Reference: #12S9018500

**RE: REDEVELOPMENT OF THE IMAX THEATRE AND SURROUNDING PUBLIC DOMAIN UPGRADES DARLING HARBOUR (SSD 7388)**

This letter is provided in response to matters raised by Transport for NSW (TfNSW) in their letter dated 8 March following review of the Transport Impact Assessment prepared by GTA Consultants as part of the above development application.

PM S 19M	metres		
Tractor Width	: 2.50	Lock to Lock Time	: 6.0
Trailer Width	: 2.50	Steering Angle	: 27.8
Tractor Track	: 2.50	Articulating Angle	: 70.0
Trailer Track	: 2.50

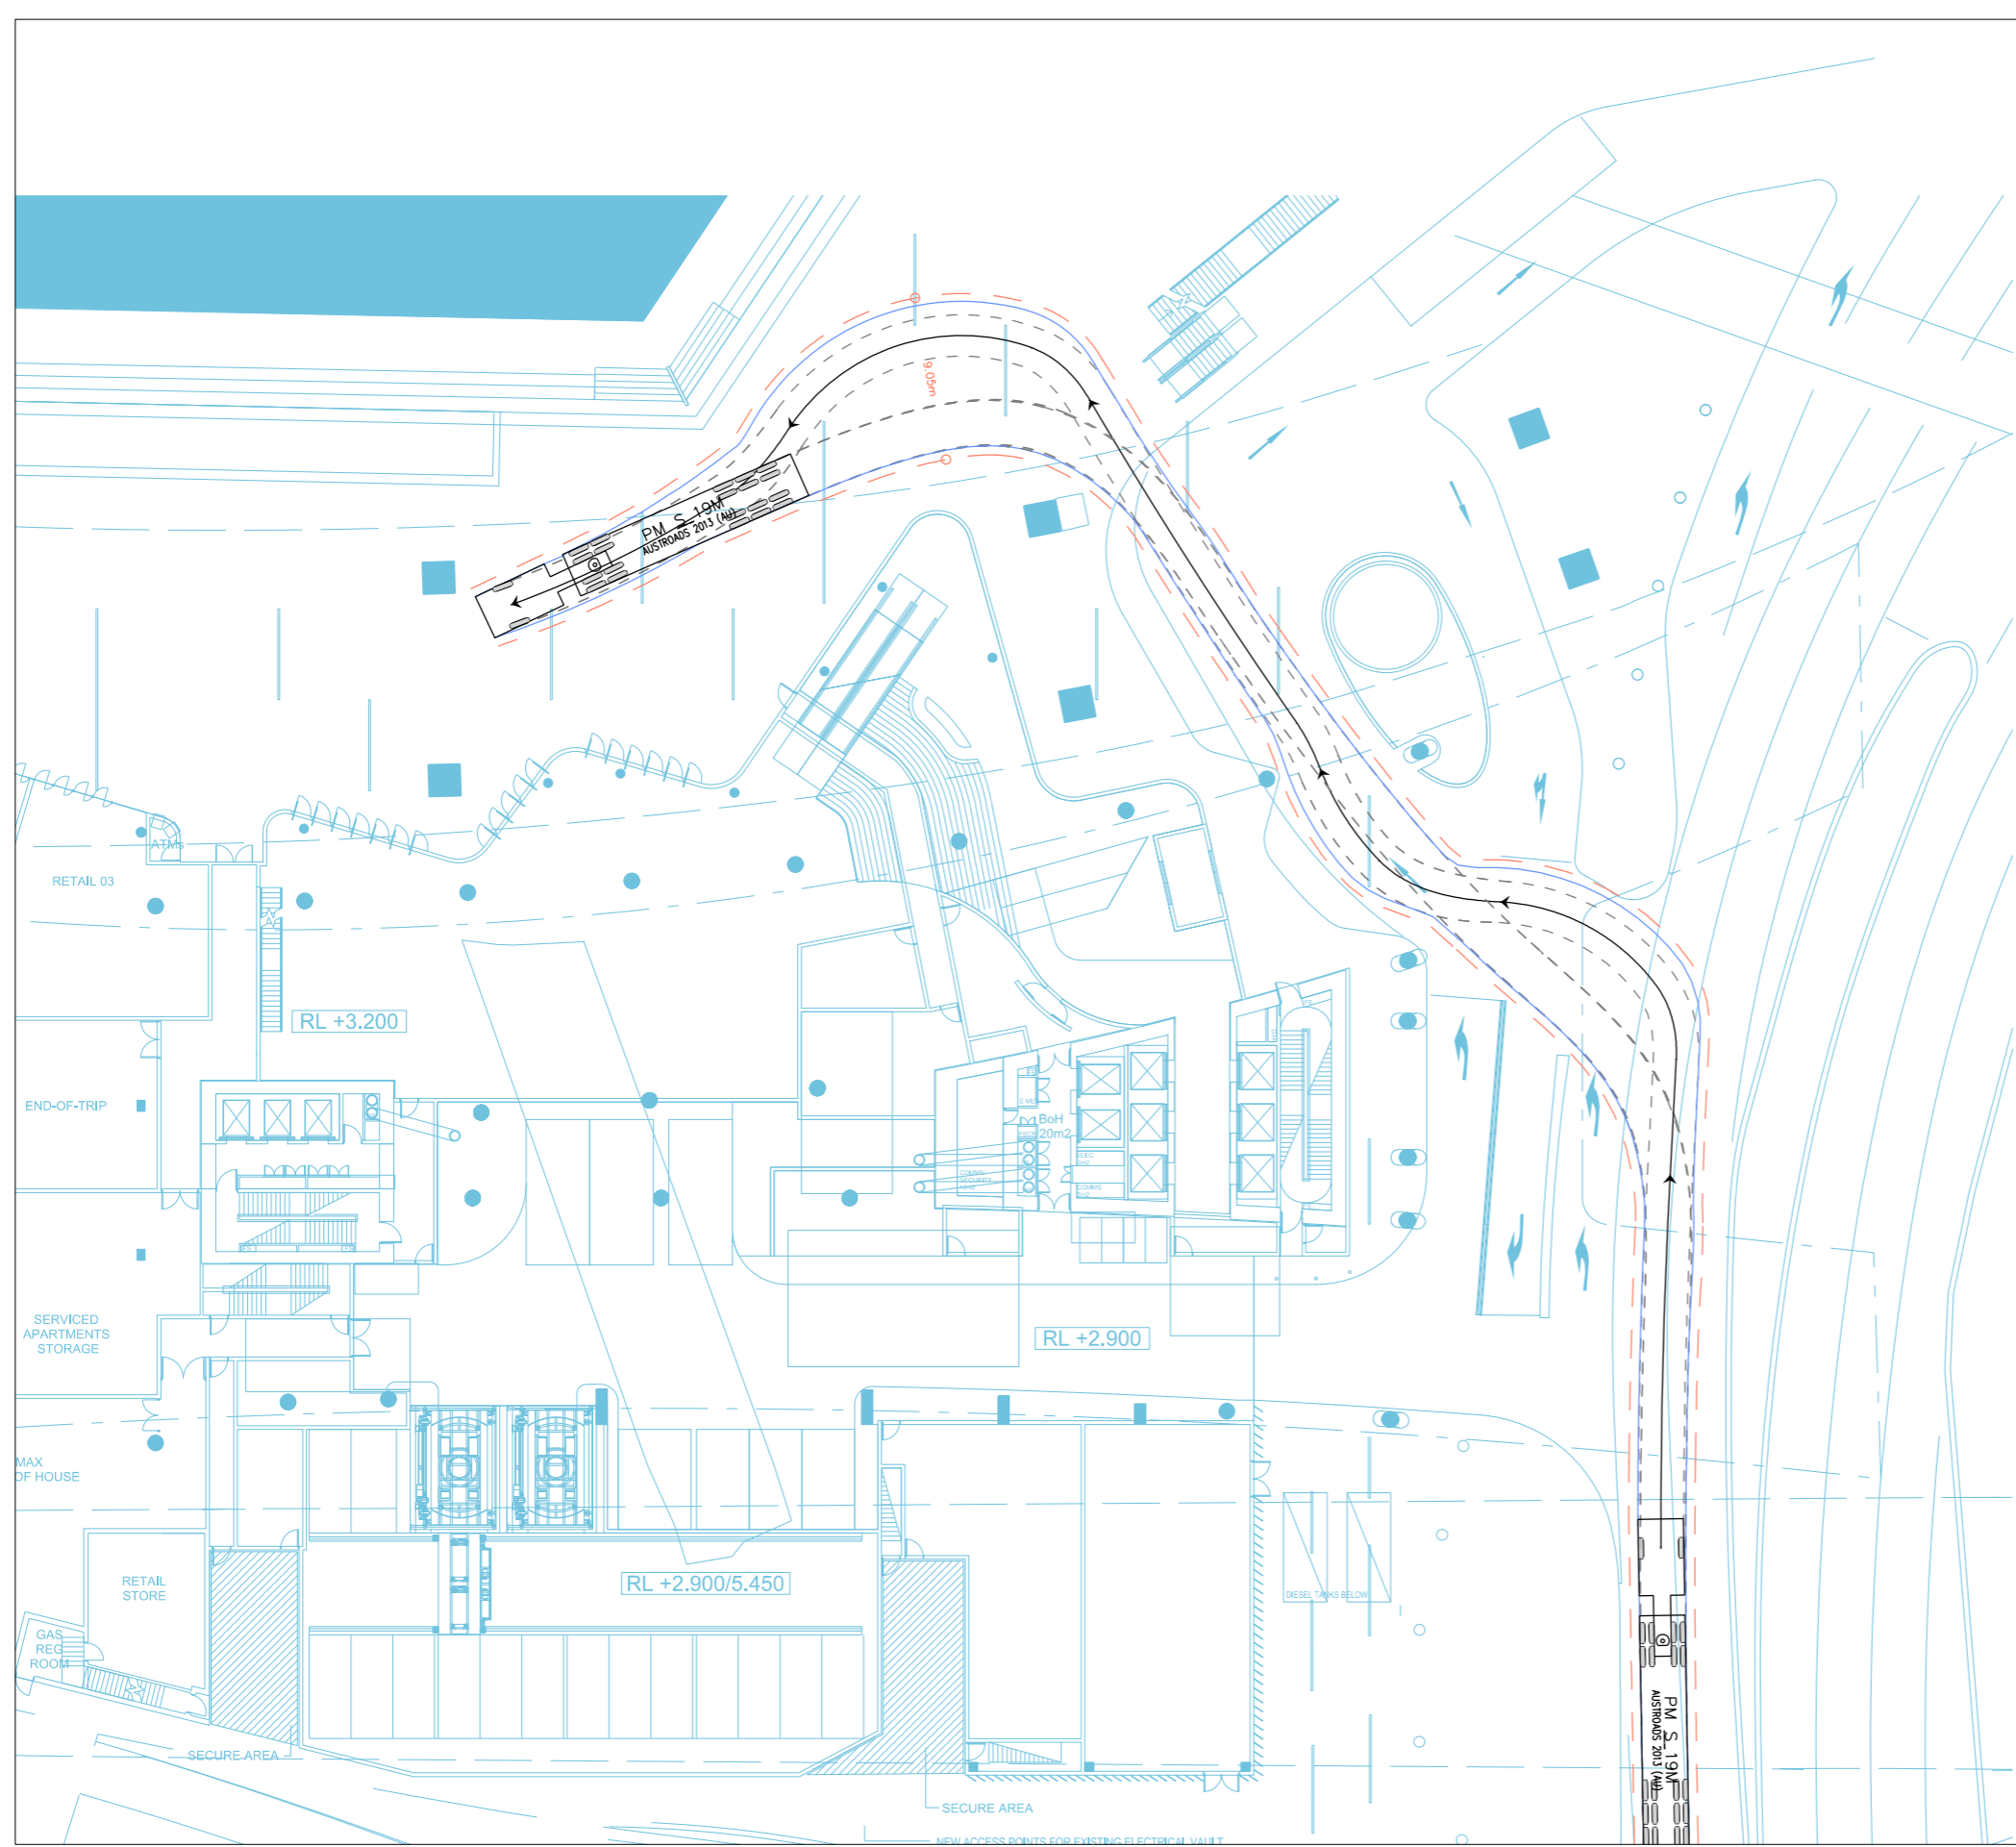
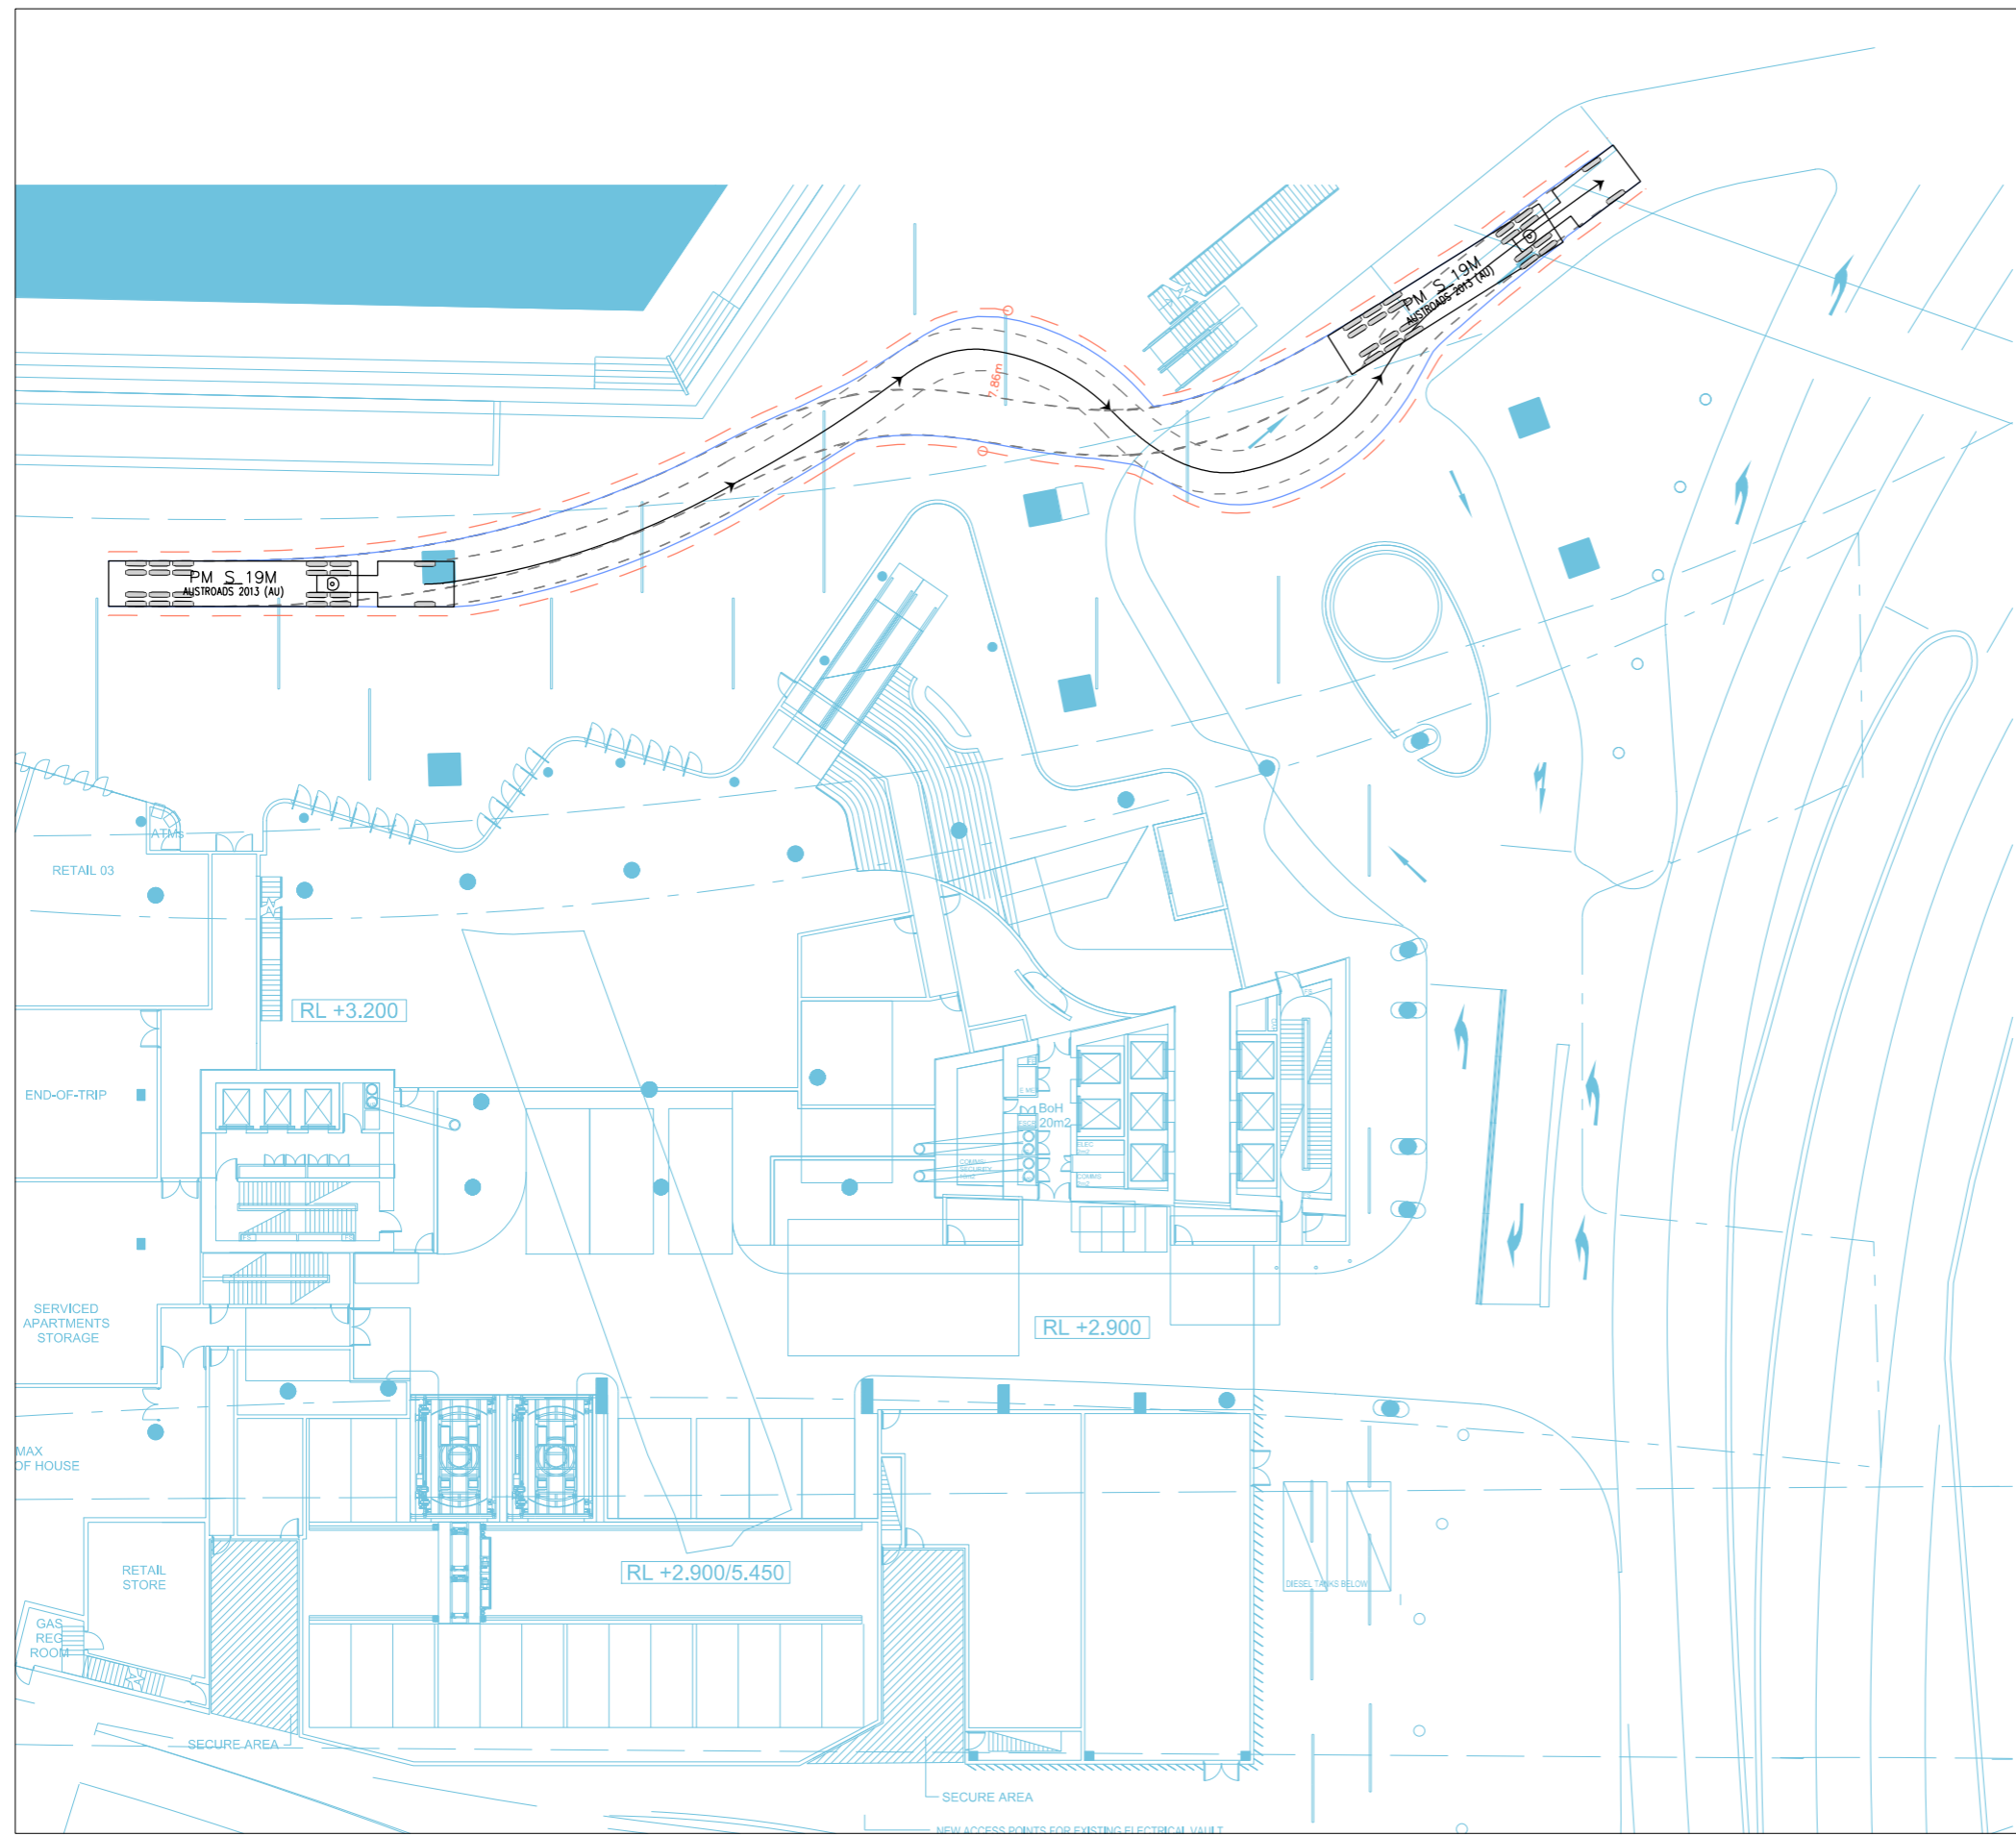
*Heavy vehicles should enter and exit in forward motion and would not be permitted to access the foreshore area as shown in Appendix A of the Transport Impact Assessment.*

To maintain Darling Harbour special event access, the site incorporates the ability for a 19m semi-trailer to access the foreshore area. The associated swept paths to satisfy SHFA requirements were included with the Transport Impact Assessment and does not reflect day-to-day operation.
